DRAWN BY: D.E. WATTS DATE: 7-13-21 DWG. NO.: 20-5498-06 SURVEYED BY: DEW, ES, 8-14-20	APPROVED BY: PROJ. NO.: DWG.	REVISIONS 4-14-22 REVISED PER CITY COMMENTS DEW	OLIVER E. WATTS CONSULTING ENGINEER COLORADO SPRINGS	PROJECT 8140 CESSNA DRIVE LOT 7, BLOCK 1, MEADOW LAKE AIRPORT FIL. NO. 2 EL PASO COUNTY	COUNTY FILE NO. PPR 2138	SHEET NAME <b>GRADING AND EROSION CONTROL PLAN</b>	SHEET NO. 1 OF 5
--	------------------------------------	---	--	---	--------------------------	---	---------------------

DRAWN BY: D.E. WATTS DATE: 7-13-21 DWG. NO.: 20-5498-07 SURVEYED BY: DEW, ESV, 8-14-20	APPROVED BY: PROJ. NO.: DWG.:	REVISIONS:	OLIVER E. WATTS CONSULTING ENGINEER COLORADO SPRINGS	PROJECT: 8140 CESSNA DRIVE LOT 7, BLOCK 1, MEADOW LAKE AIRPORT FIL. NO. 2 EL PASO COUNTY	SHT. NAME: EROSION CONTROL DETAILS	SHT. NO.: 2 OF 5
---	-------------------------------------	------------	--	--	---------------------------------------	---------------------

DRAWN BY: O.E. WATTS DATE: 11-8-21 DWG. NO.: 20-5498-08	APPROVED BY: PROJ. NO.: DWG.	REVISIONS 4-14-22 REVISED PER CITY REVIEW COMMENTS OEW	OLIVER E. WATTS CONSULTING ENGINEER COLORADO SPRINGS	PROJECT 8140 CESSNA DRIVE LOT 7, BLOCK 1, MEADOW LAKE AIRPO

COUNTY FILE NO. PPR 2138

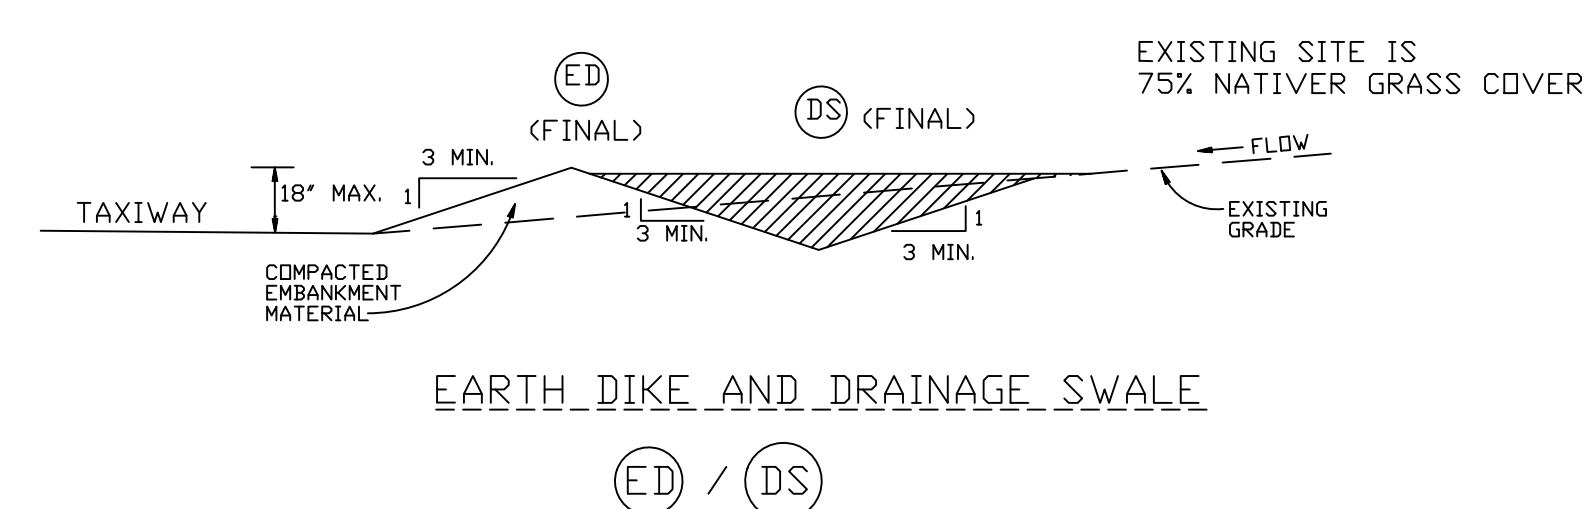
Please change to initial/interim as the Notice to Proceed cannot be issued until the VTC is installed.

FIGURE OS-4 ORIFICE PLATE AND TRASH RACK DETAILS AND NOTES

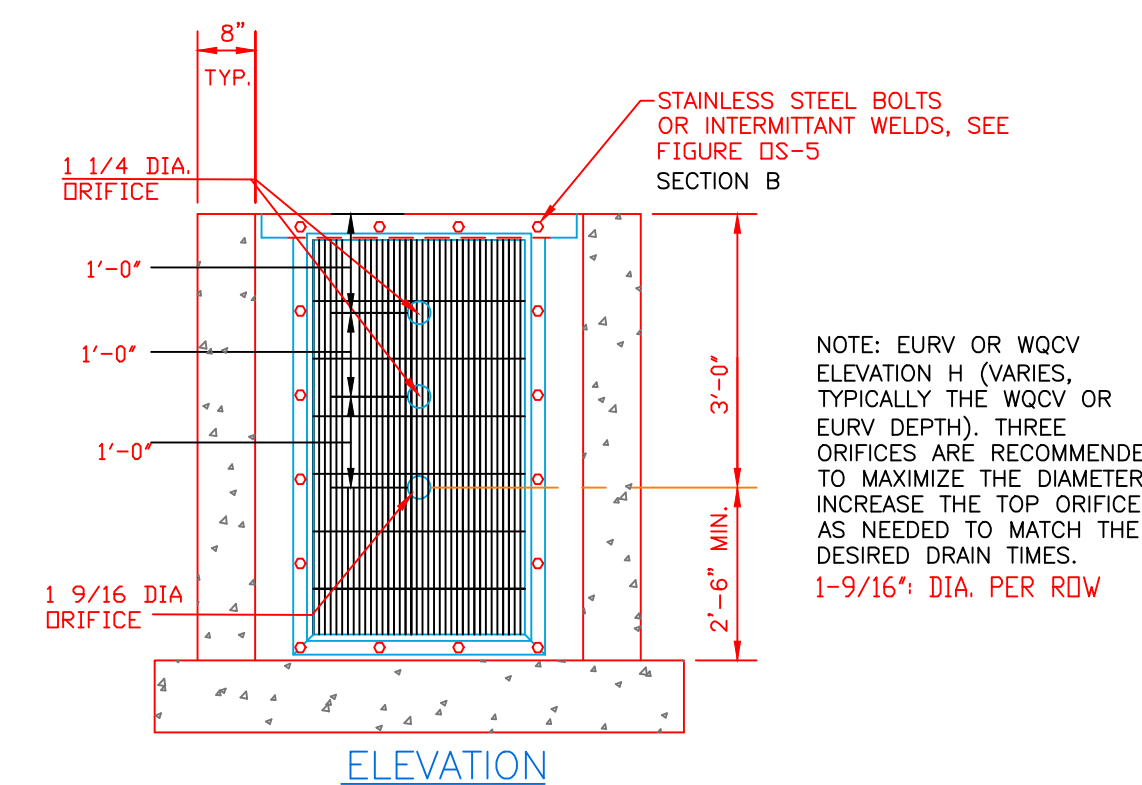
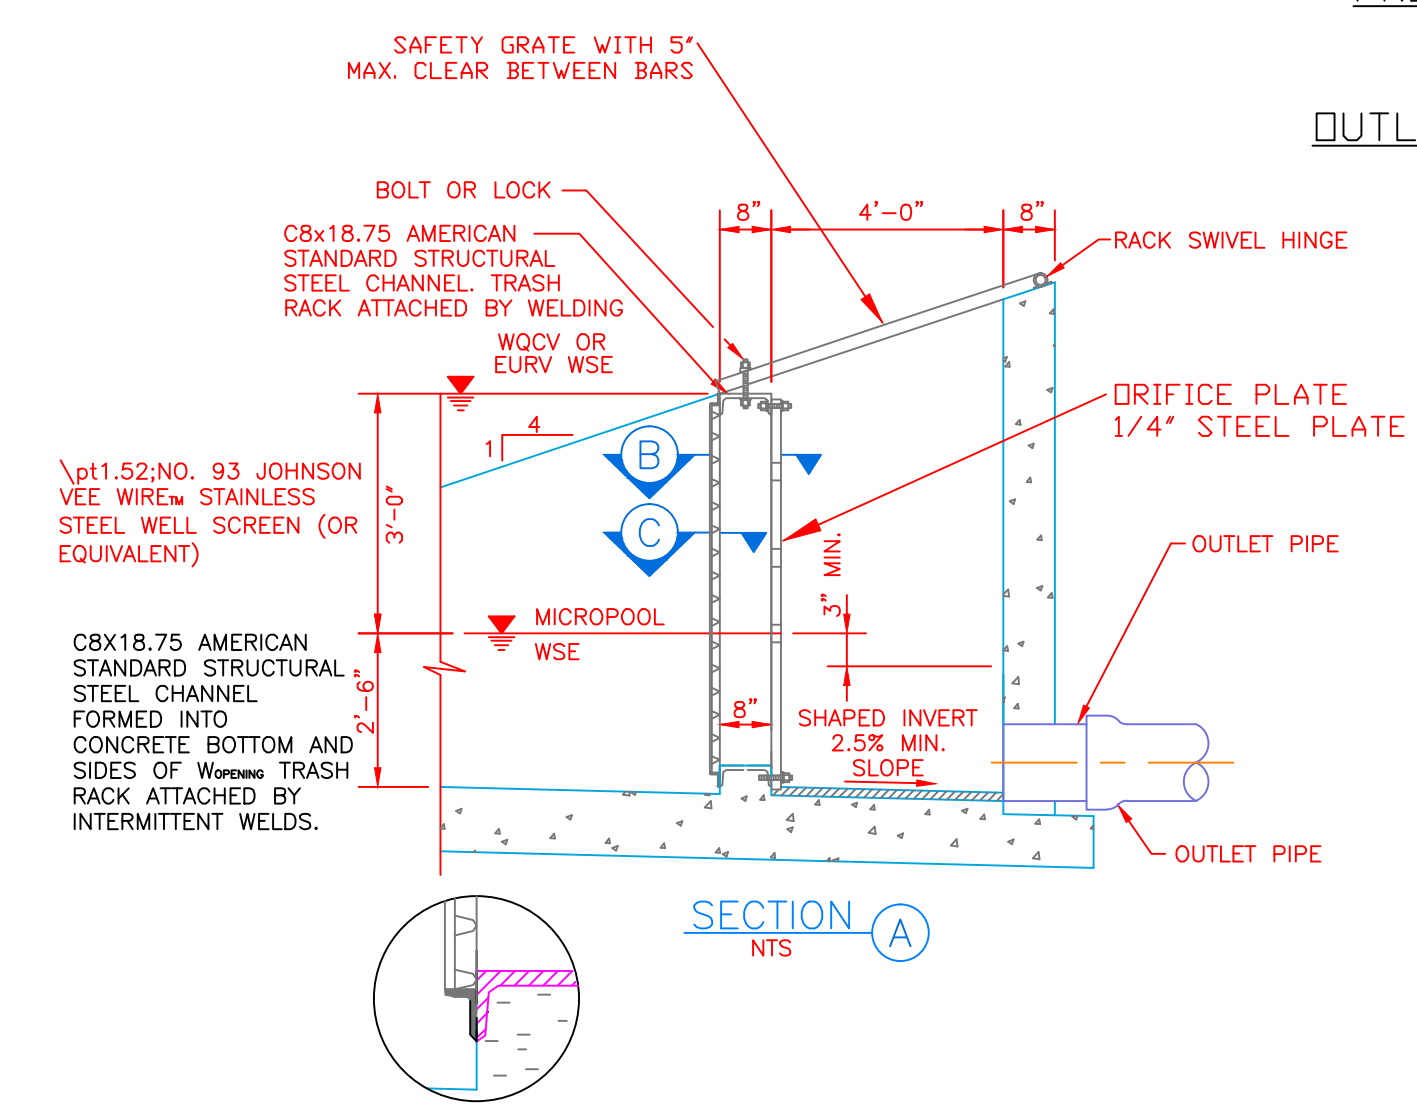
Please remove or change to 1-9/16" to avoid confusion in the field.
